Our ref: XA/2024/100072/01-L01
Your ref: EN010122
Date: 3 May 2024

PRE-EXAMINATION - SOLAR FARM. INTERESTED PARTY RELEVANT REPRESENTATION. OAKLANDS FARM SOLAR PARK, DERBYSHIRE.

We have reviewed the draft DCO, Environmental Statement (ES) and supporting documents submitted to the Planning Inspectorate as part of the above-mentioned application.

**Figure 3-1 Planning flood zones 2 & 3**

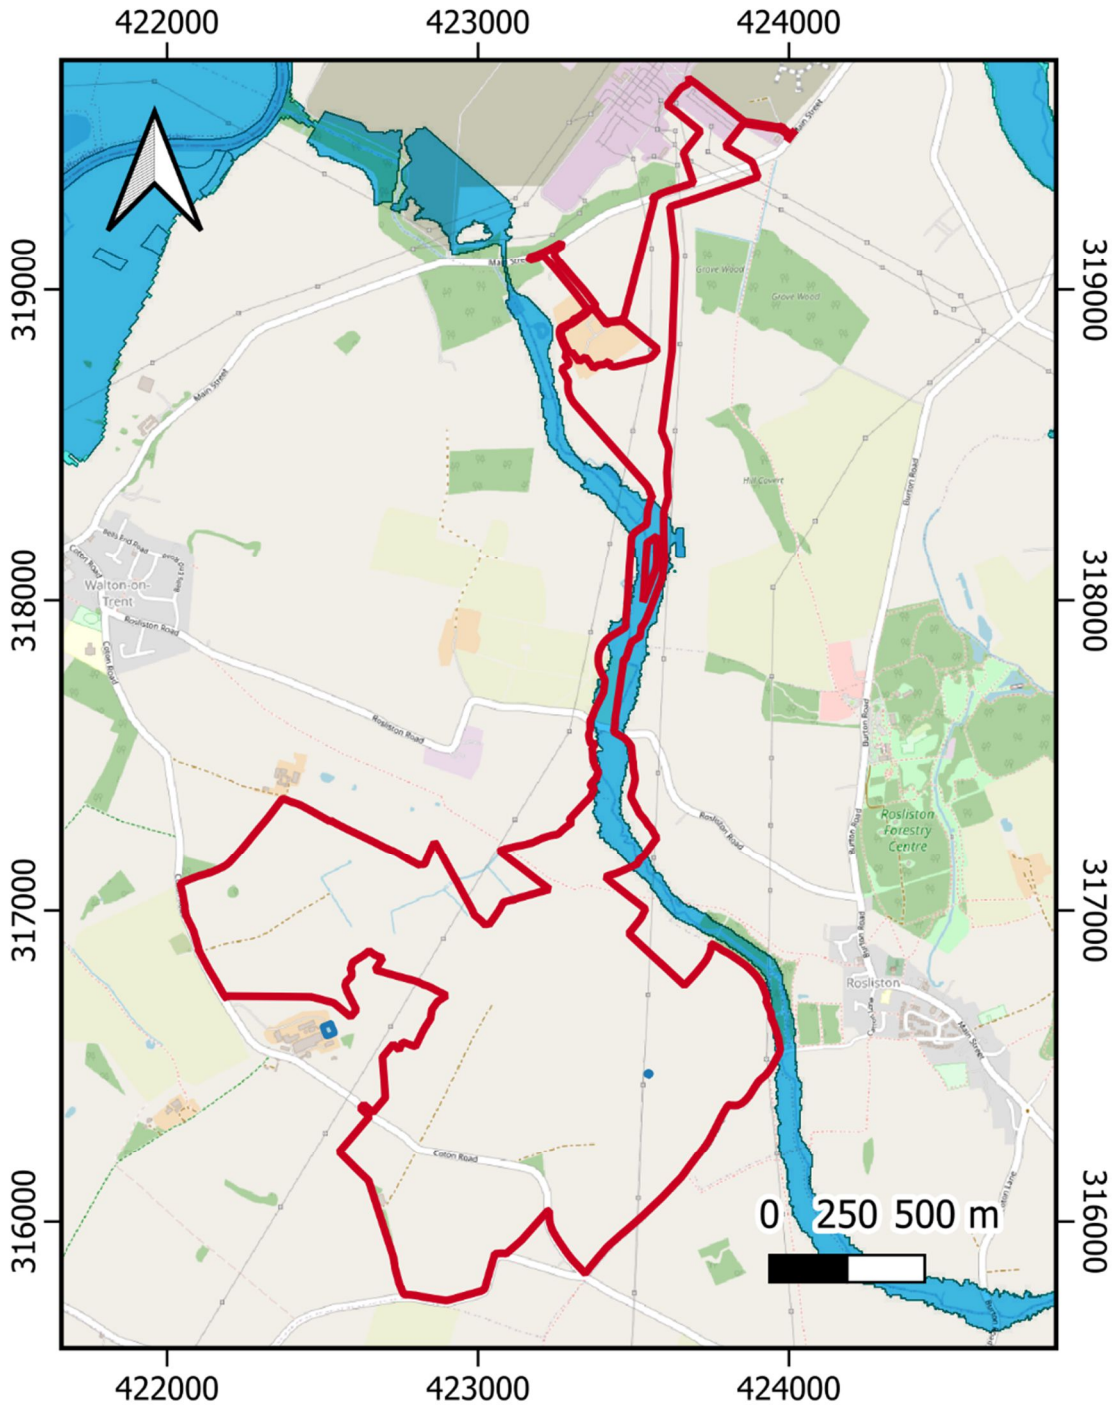
Fluvial flood risk has not been properly assessed. There remains a risk of increased flood risk on or off site.

The FRA only uses the Flood Map for Planning to assess fluvial flood risk. This map is only intended as a planning tool to prompt where a more detailed assessment of flood risk may be required. The Flood Map for Planning does not account for future flood risk, taking climate change into consideration, and is also not detailed enough to cover any catchments smaller than 3km² (regardless of whether there is an associated fluvial flood risk or not). The Flood Map for Planning identifies areas of the site as being within Flood Zone 2 and 3, so further assessment of this fluvial flood risk is required.

It is the Applicant's responsibility to appropriately assess the flood risk associated with their proposed development. For a development of this scale with a vulnerability classification of 'essential infrastructure' we would expect any assessment of fluvial flood risk to be based on detailed flood modelling. Given that the source of fluvial flood risk within the red line boundary originates from Ordinary Watercourses, it is recommended that the Applicant should contact the Lead Local Flood Authority to determine whether any detailed flood modelling already exists.

Figure 4.11: Indicative Access Track  
Cross Sections (4.5m/6m/3.5m)

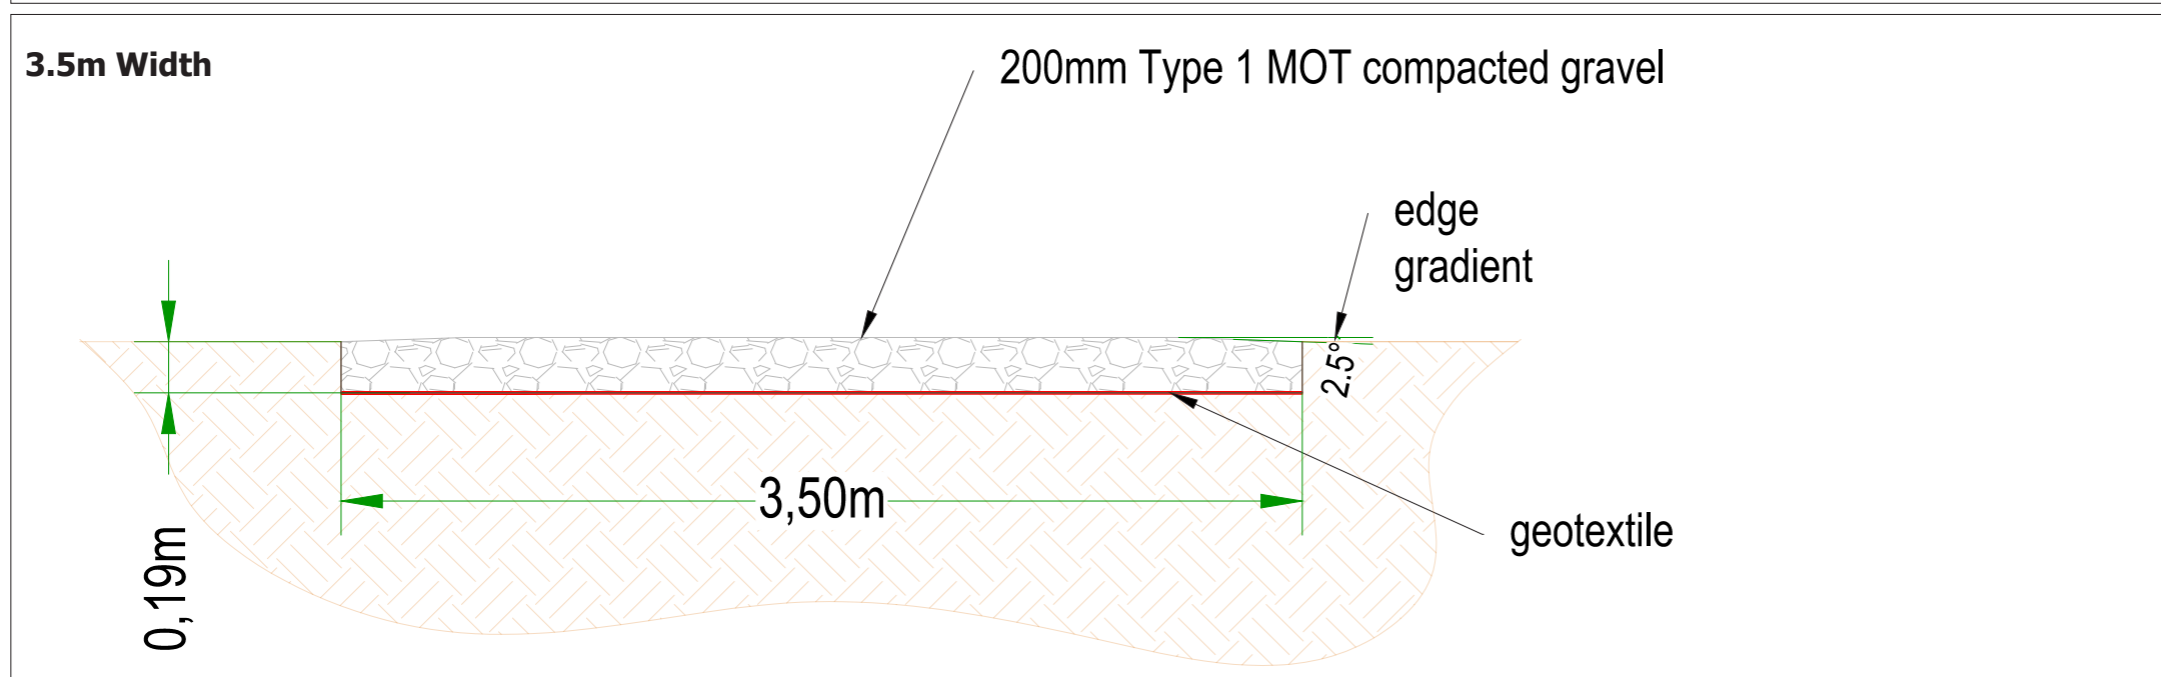
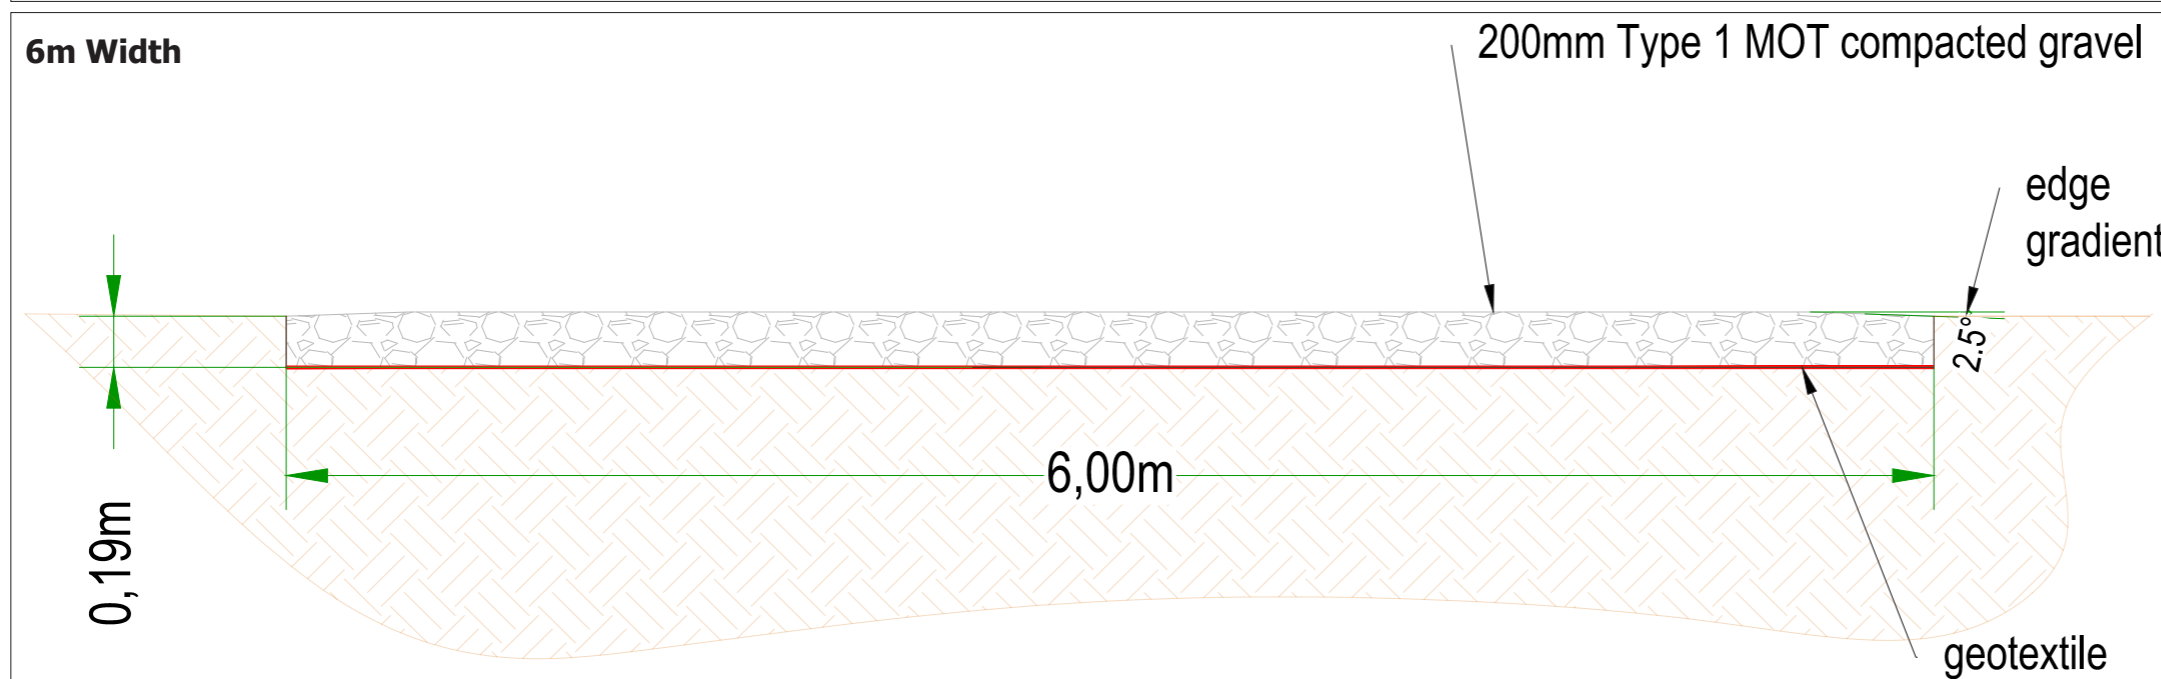
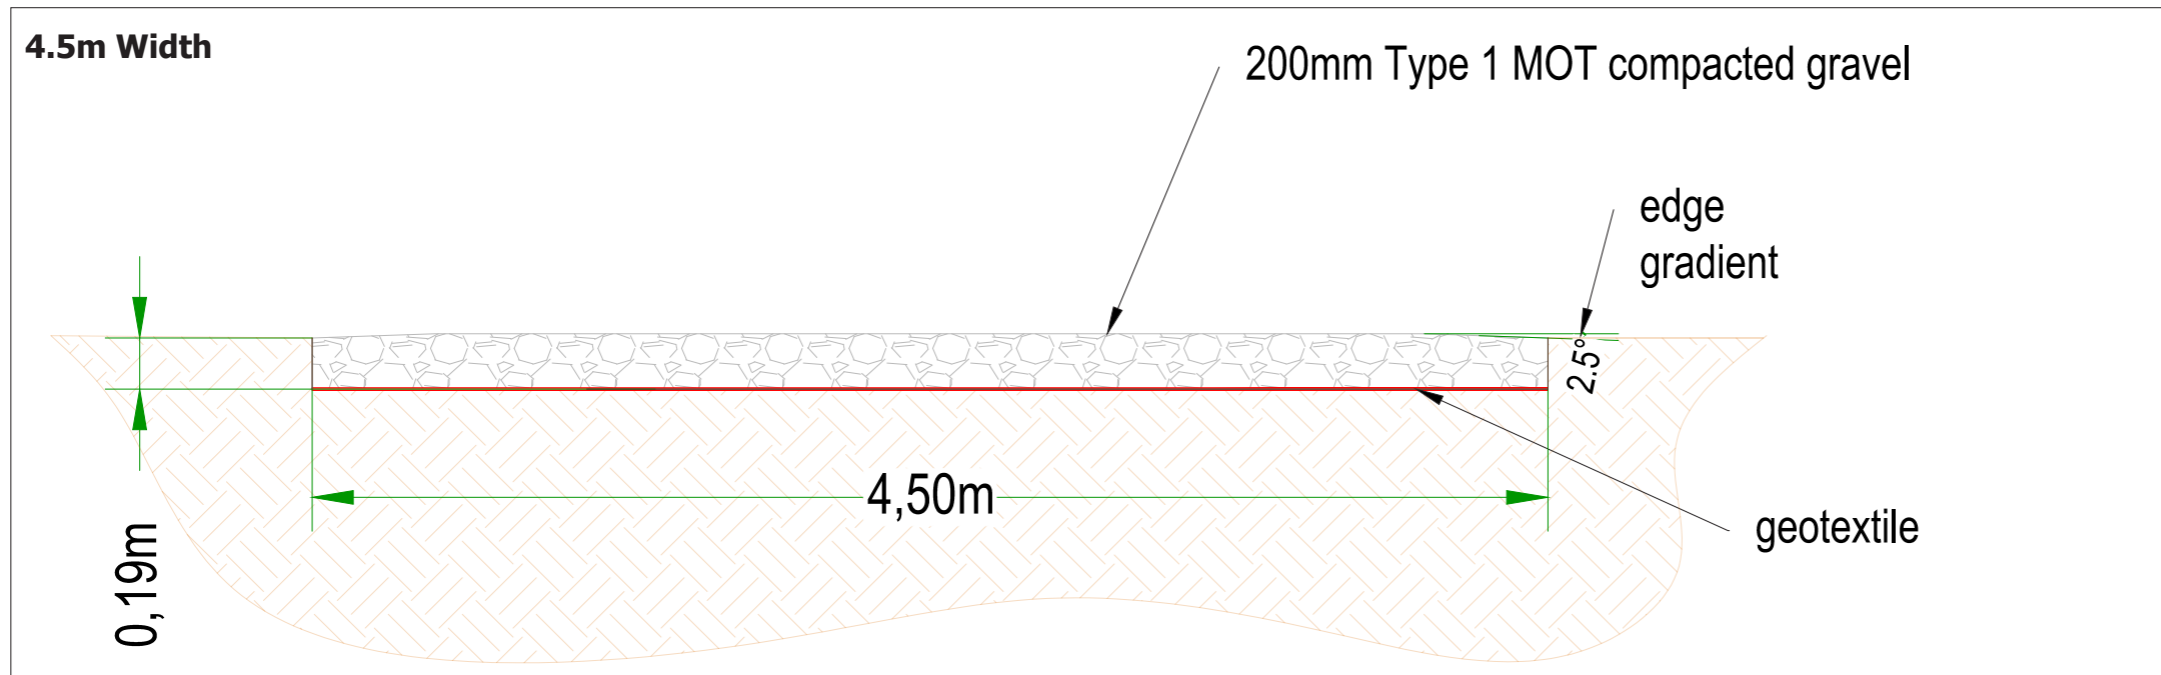
Hydro-morphological impacts have been screened out from further assessment.

The proposed trackway crossings will lead to the culverting of watercourses. There is a risk that the physical characteristics and water content of waterbodies will be adversely affected.

Hydro-morphology should be scoped into the WFD Assessment to fully assess the impact of the proposed trackway crossings on river morphology.

Ideally these trackways should be open span bridges to allow natural sediment movement and reduce the impact to the river morphology. However, if this is not possible then it is recommended that the invert of the culvert be set a minimum of 300mm below the existing bed so that there shall be no step or drop in the final level of the bed.
